Application No: FP/157/20/HH
Site Address: 24 Goodwood Avenue Felpham PO22 8EH
Description of works: Proposed Roof Extensions & Alterations

Thank you for your internet representation made on 15th October 2020 which has been recorded as an objection with the comments as follows:

CLIENT	Mr & Mrs J Fowles	DRAWING	003 Proposed Elevations
SITE	24 Goodwood Avenue, Felpham	DATE	20 08 20
PROJECT	Proposed Extensions & Alterations	SCALE	1: 100 @ A3
		AUTHOR	AH
		STATUS	PL

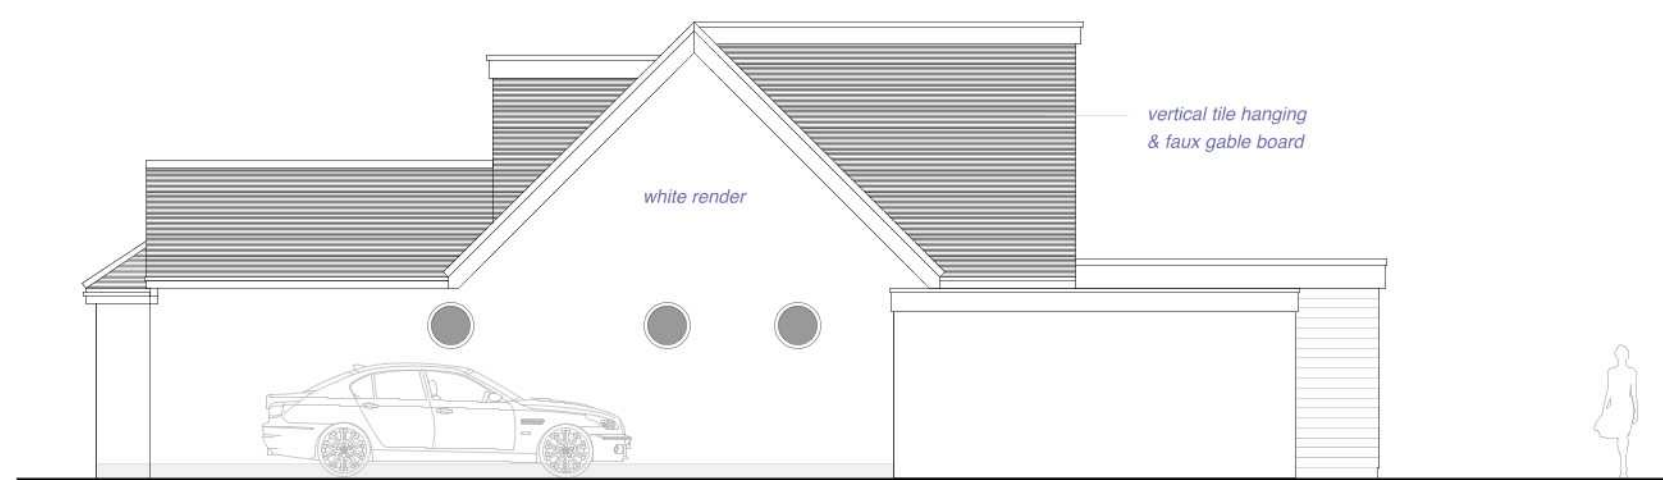
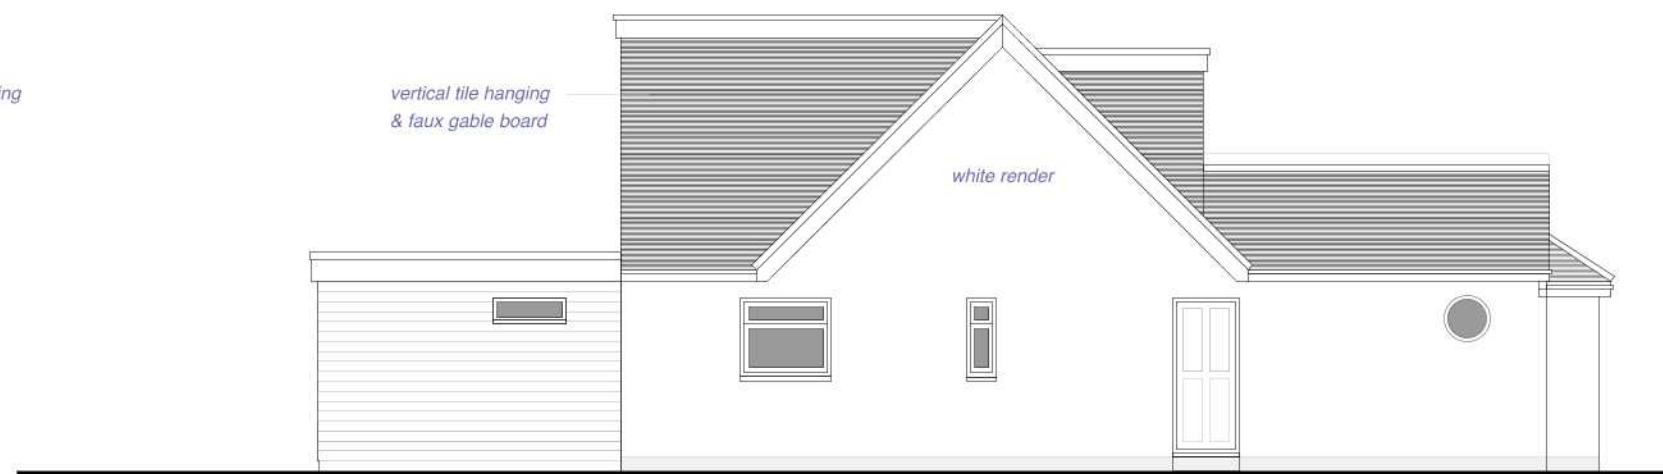
Whilst I have no objection to the principle of converting roof space into habitable use, for this Application I have concerns that the finished appearance and roofline will not be in keeping with other properties in the road, including some with roof extensions of a more sympathetic style.
